PROPERTY SURVEY

Proposed changes to site:

S.B. = Existing Set-Backs

PROPERTY SURVEY

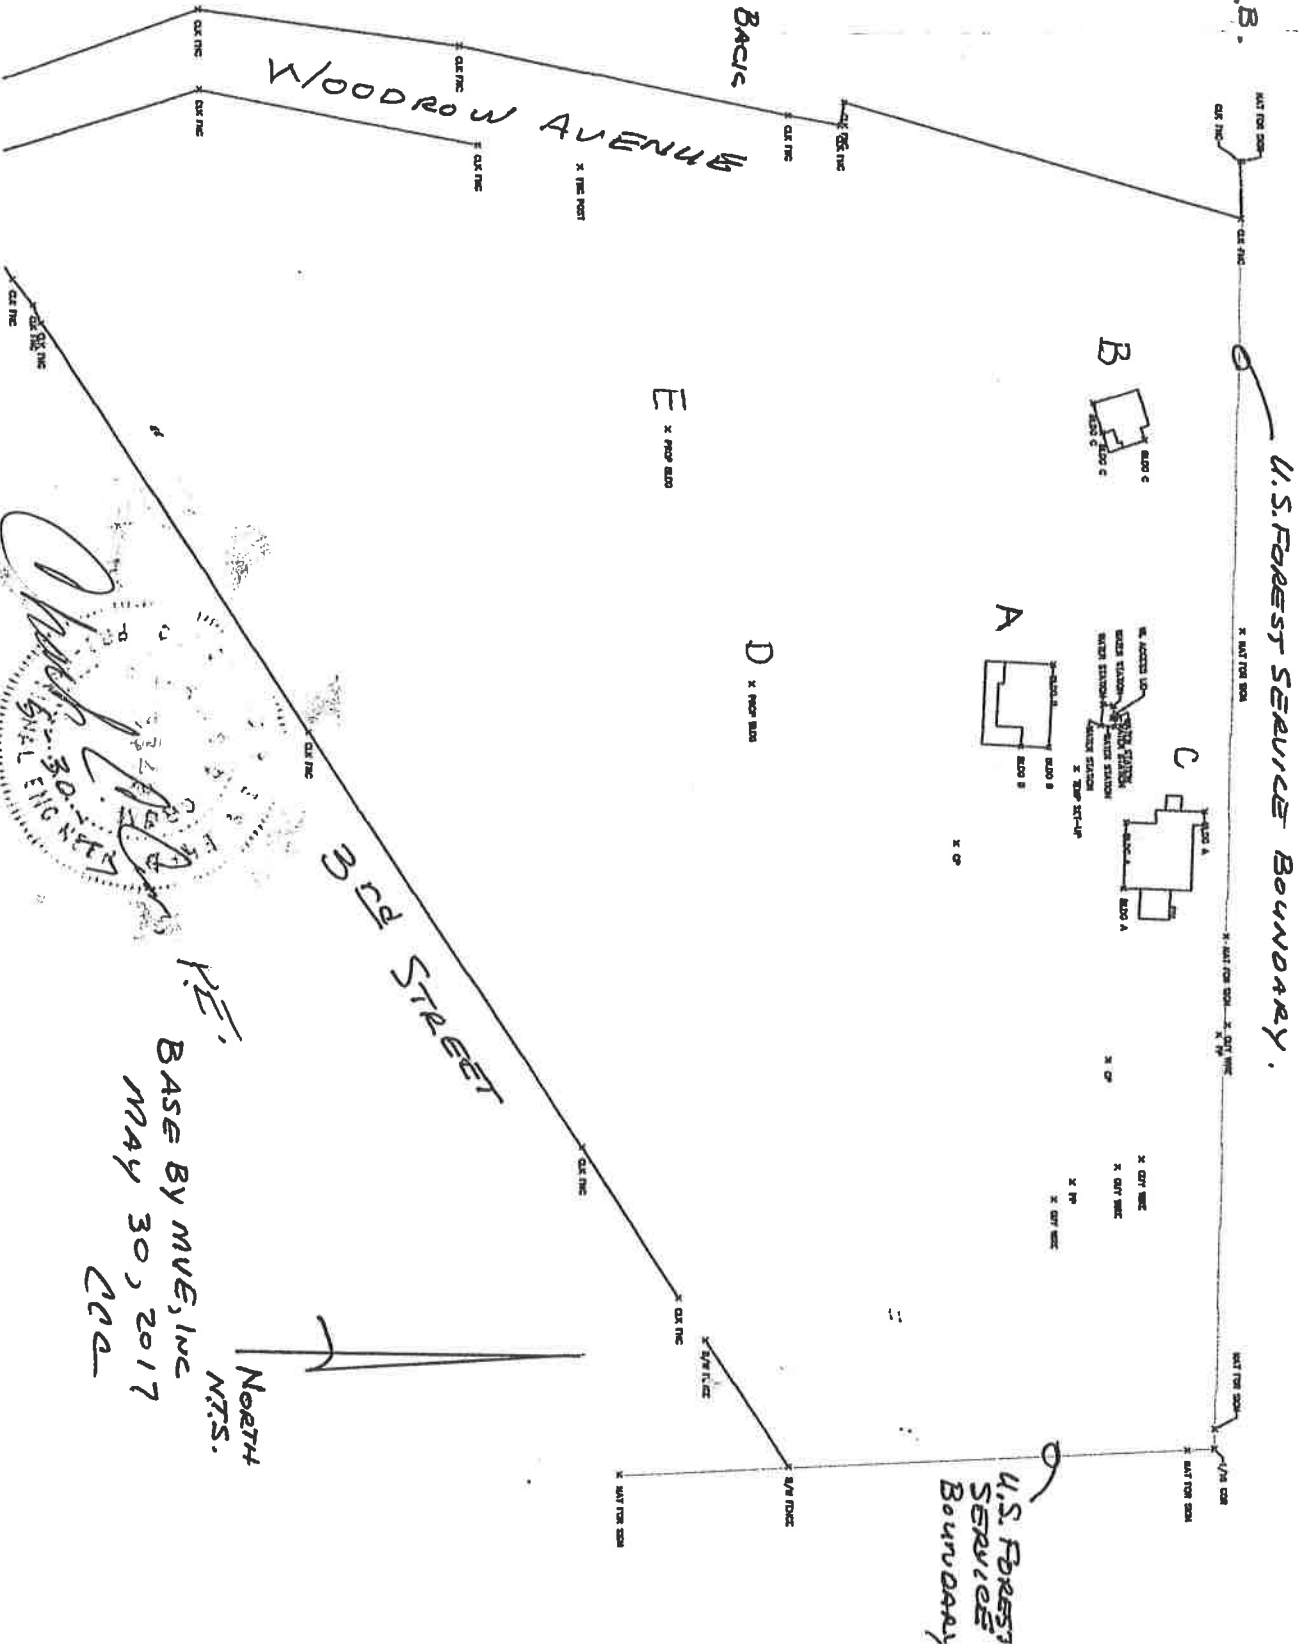
This is not legible

Show setback encroachment

Please show access once permit is approved.
